Application Number: 21/00241/F

Proposal: Redevelopment of the former Lombard Service Station to provide 10 self-contained residential flats.

Address: Lombard Service Station Brook Road Southville Bristol BS3 1AJ

Following a review of the documentation, Bristol Waste has considered the waste and recycling provision for the development at Lombard Service Station Brook Road Southville Bristol BS3 1AJ.

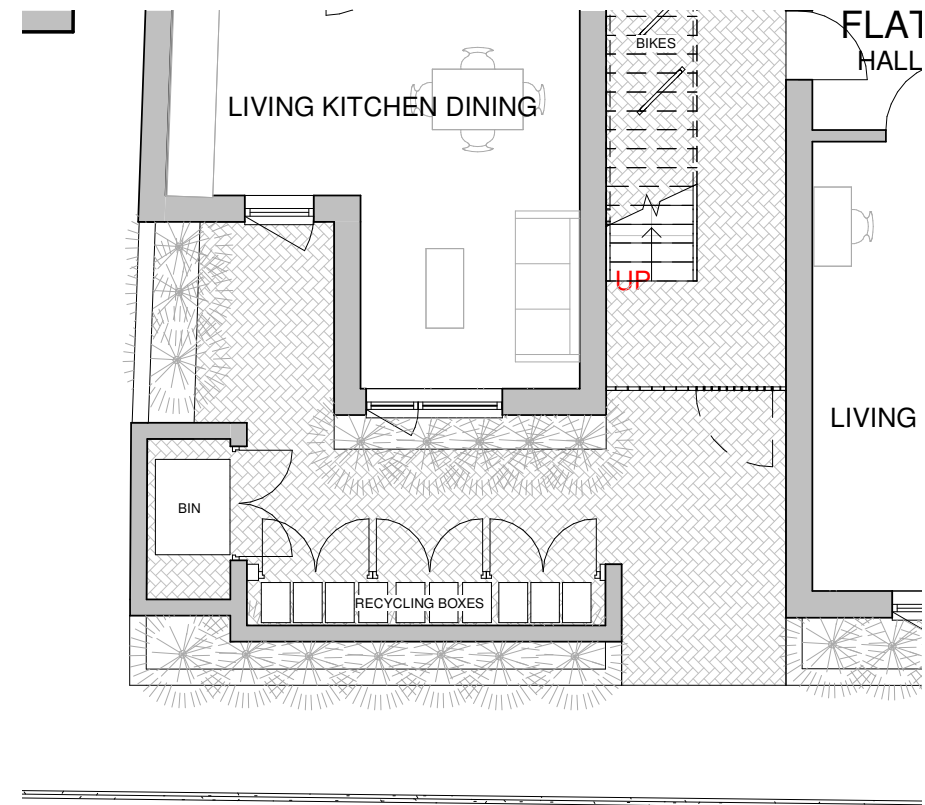
The waste strategy section 4.5 does not mention 90l sacks used for Cardboard. The pavement outside must be level and flat to move the four wheeled bin and the kerb must be dropped and parking restricted to allow the servicing of the bin without parking restricting access. We would urge at this stage of the planning process that the developers refer to the Planning Guidance for Waste and Recycling produced by Bristol Waste Company. When considering the layout, access and the design of the bins stores, this guide contains a wealth of information regarding the bin volumes, requirements etc. <http://www.bristolwastecompany.co.uk/resources/>
